CONSULTATION RESPONSE

CONSERVATION + DESIGN

2018/91490

Holme House Care Home, Oxford Road,
Gomersal, Cleckheaton. BD19 4LA

PROPOSED SITE PLAN 1:200 @ A1

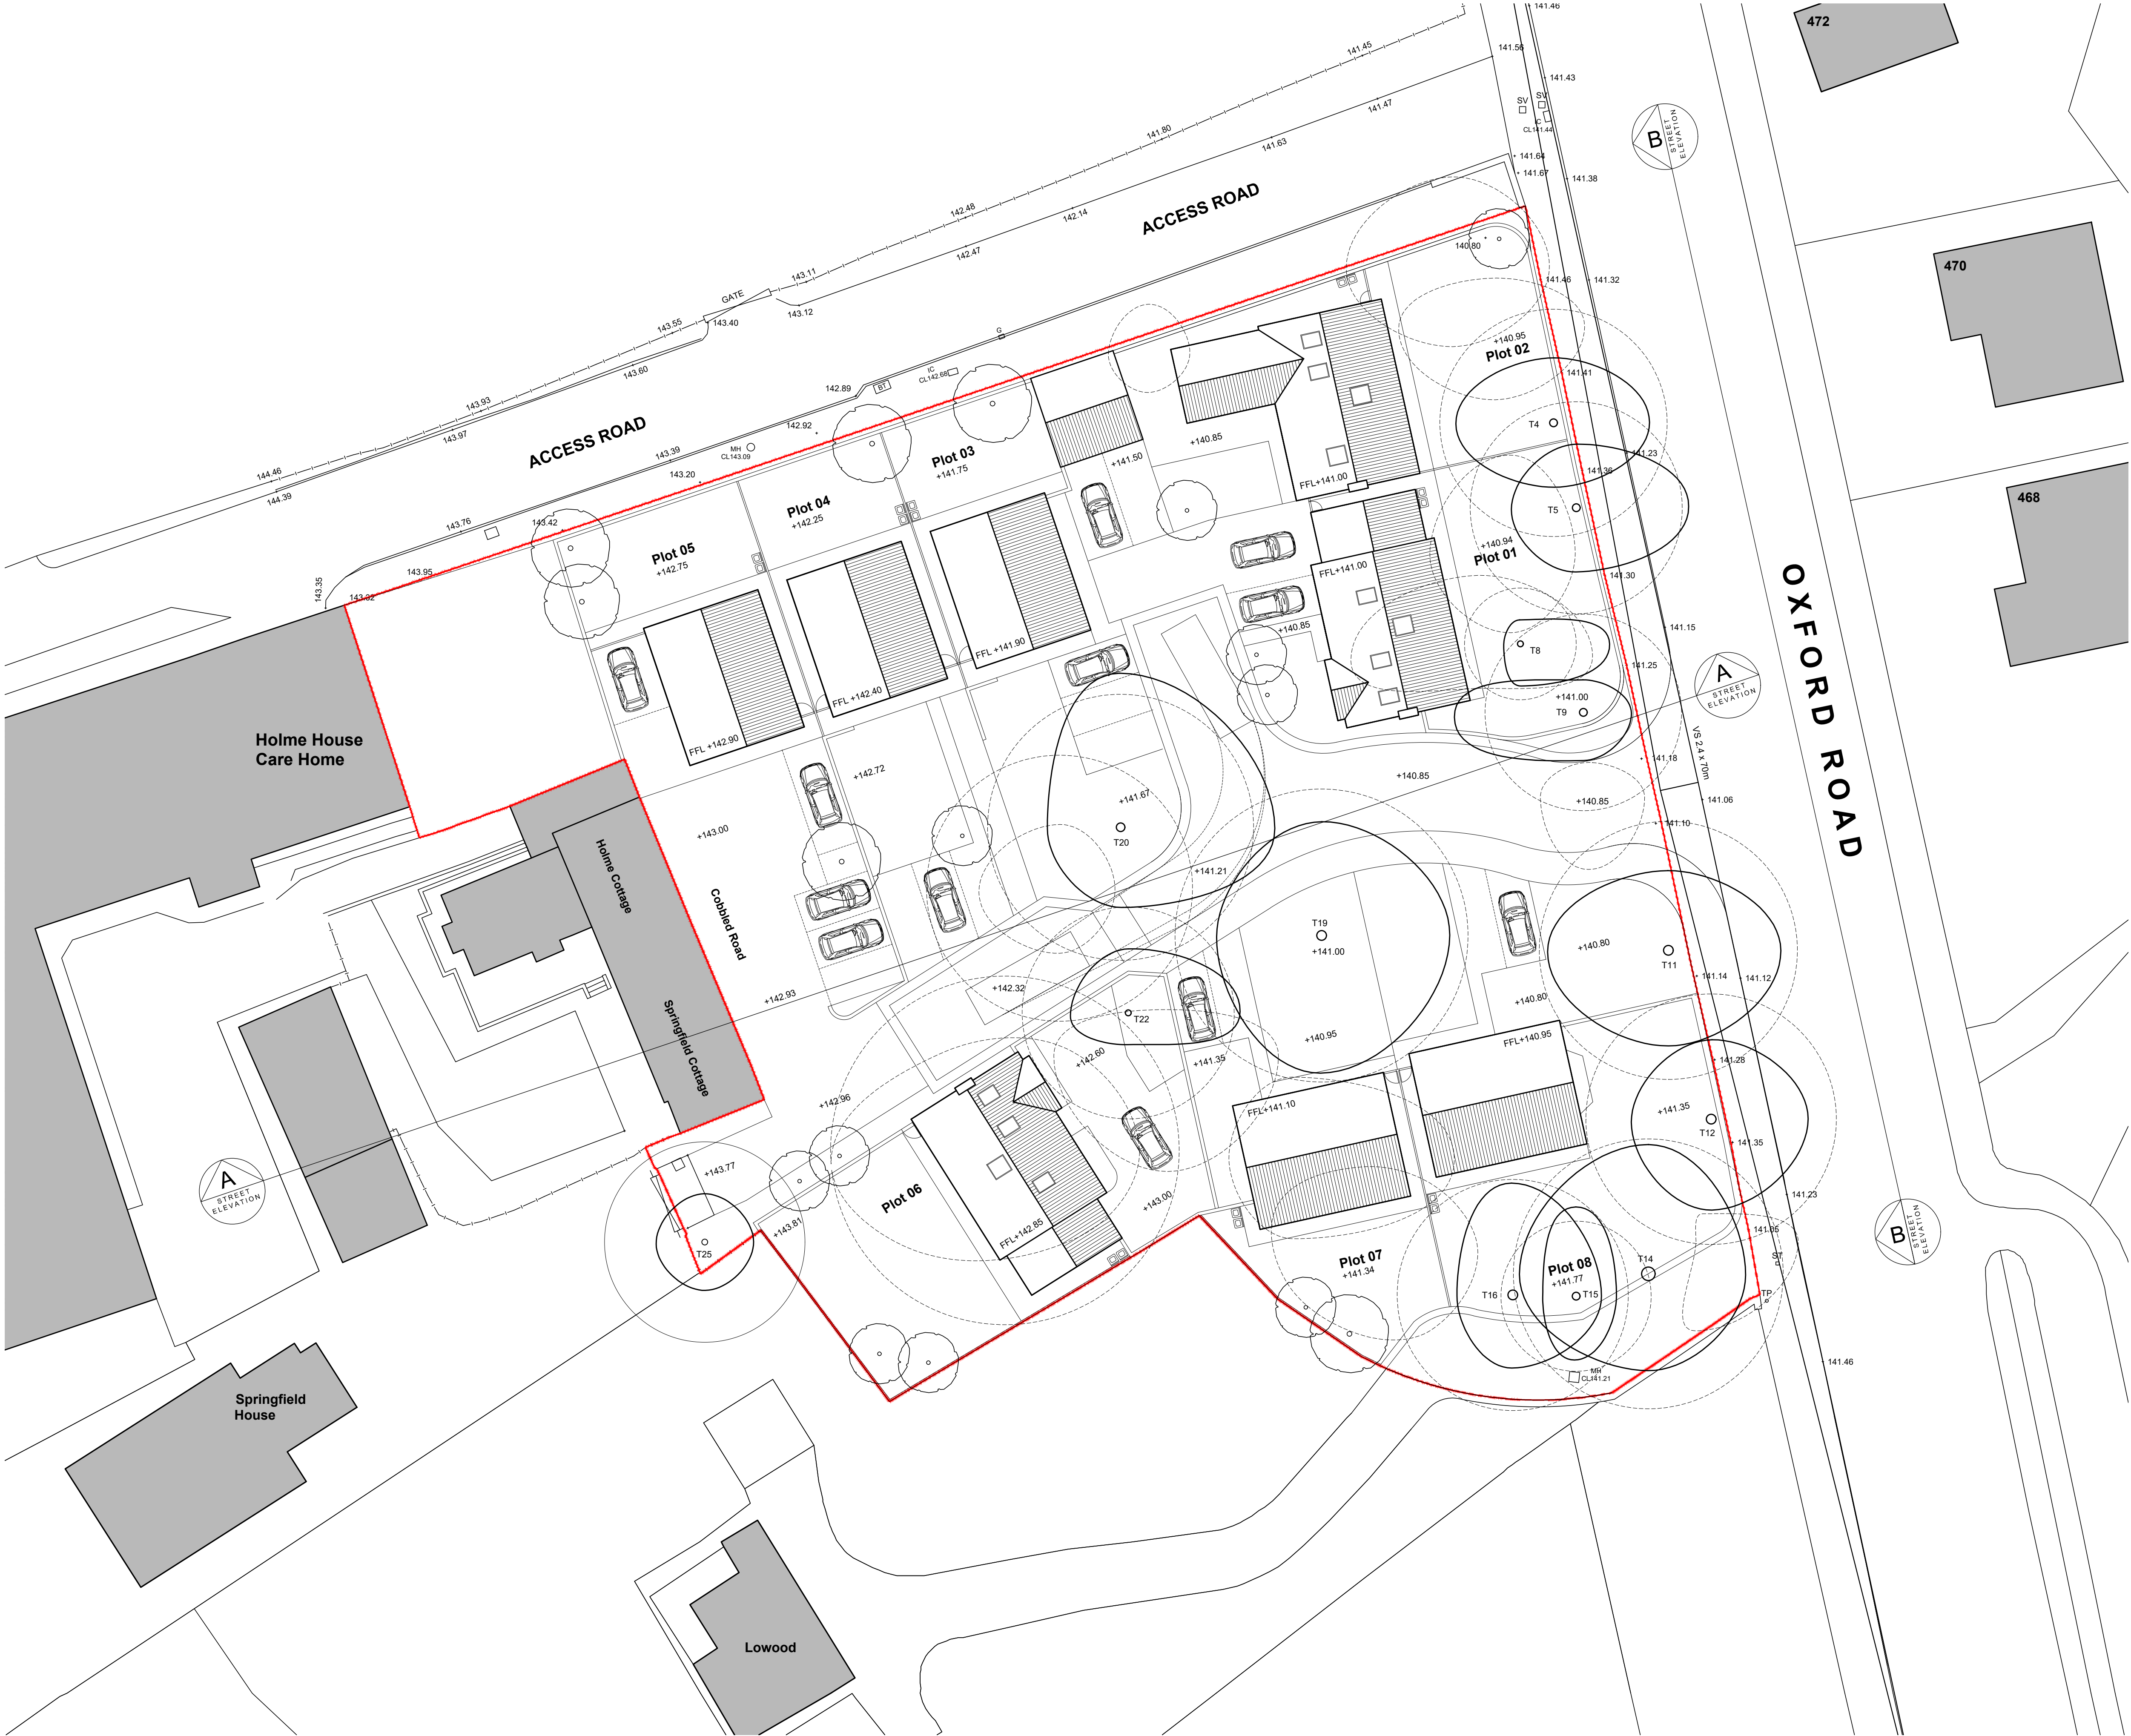
I have concerns about the scale of units 3-5 due to the roof space being used & they are close together. However, I do not believe it's a major issue
